Consultation Response from: KC Environmental Health (Pollution & Noise Control)		
2021/93674 Greenhead College, Greenhead Road, Huddersfield, HD1 4ES		
Partial redevelopment of Greenhead college including demolition and making good, erection of 2 and 4 storey buildings, reconfiguration of parking and access arrangements, reconfiguration of sports provision and other associated external works (Within a Conservation Area)		
Date Responded: 7th December 2021	Responding Officers: Mohammed Nasim – Noise Natalie Heaney – Contaminated Land Rebecca Muff – Air Quality	Responding Ref: WK/202140632
In our initial consultation dated 9th November 2021 we reviewed the submitted information and recommended conditions for: Kitchen Extract Scheme, Contaminated Land, Ground Gas, Noise, External Artificial Lighting, Hours of Use, Construction Environmental Management Plan, Electric Vehicle Charging Points and Pollution Prevention. Since our previous comments of 9th November, further information has been submitted which has been reviewed and we make the following comments and recommendations, which supersedes our previous comments for these areas. Conditions relating to the Kitchen Extract Scheme, Ins

Figure 7: Noise barrier to the roof level plant area west elevation

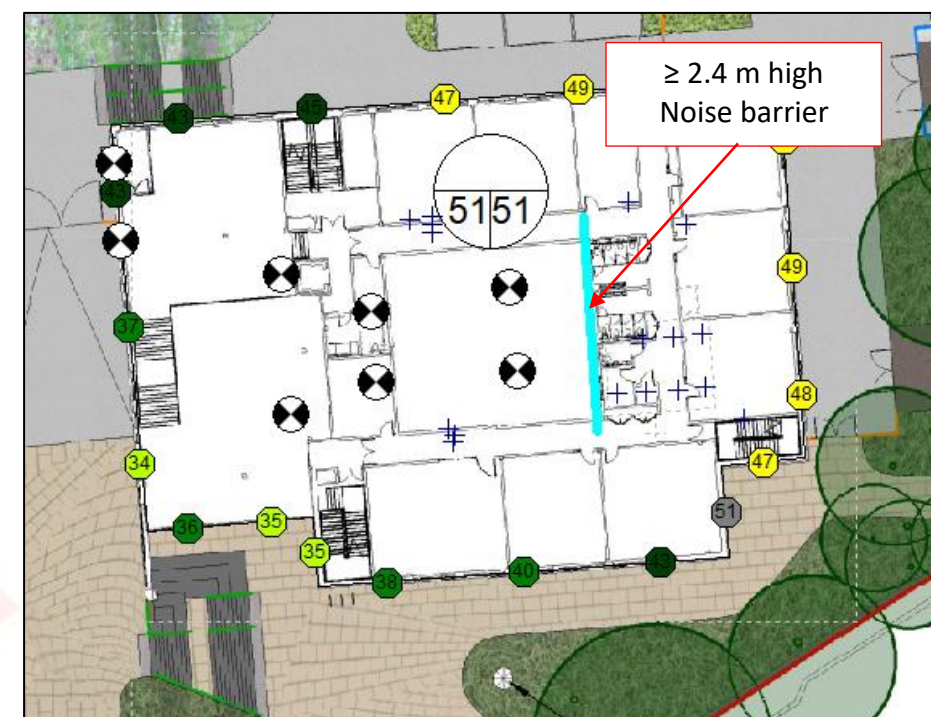
Apex state a reduction in the number of ASHPs (Air Source Heat Pumps) is now proposed compared to that current at the time of their initial report, with units also being relocated further away from the existing college façade, reducing the risk of adverse noise impact, including at the existing college façade. Apex state that mechanical plant and attenuator selections shall be based on Table 5 plant noise limits within the report. Detailed plant noise impact assessment based on BS 4142 at nearby dwellings shall be carried out once final plant selections have been confirmed. Our position remains that a condition requiring a further assessment of the proposed plant and the associated noise levels during operation must be undertaken once these details are confirmed.

A condition is also recommended to ensure the mitigation measures proposed (2.4m high solid screen) is installed as per the location and specification given.

Figure 8: Noise barrier to the west and south of the sports pitch

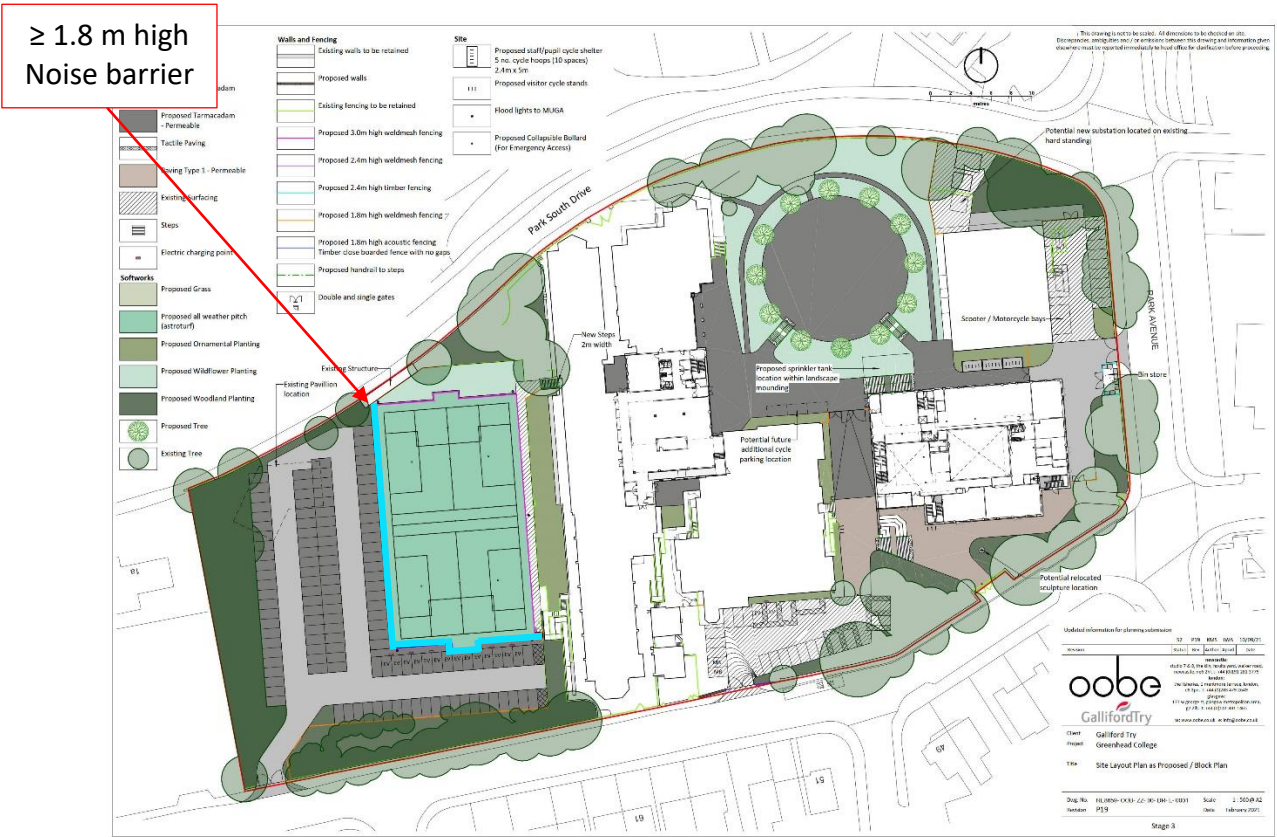
Apex state their report has been updated to include reference to noise levels due to a hockey ball hitting a resilient material treated backboard. The applicant will need to ensure all pitch perimeter fencing is installed in accordance with the Design Guidance Note from Sport England - Artificial Grass Pitch (AGP) Acoustics - Planning Implications and a condition is recommended to ensure it is installed as per this guidance document.

All other noise mitigation fencing is to be installed as per the location and specification given and a condition is recommended.
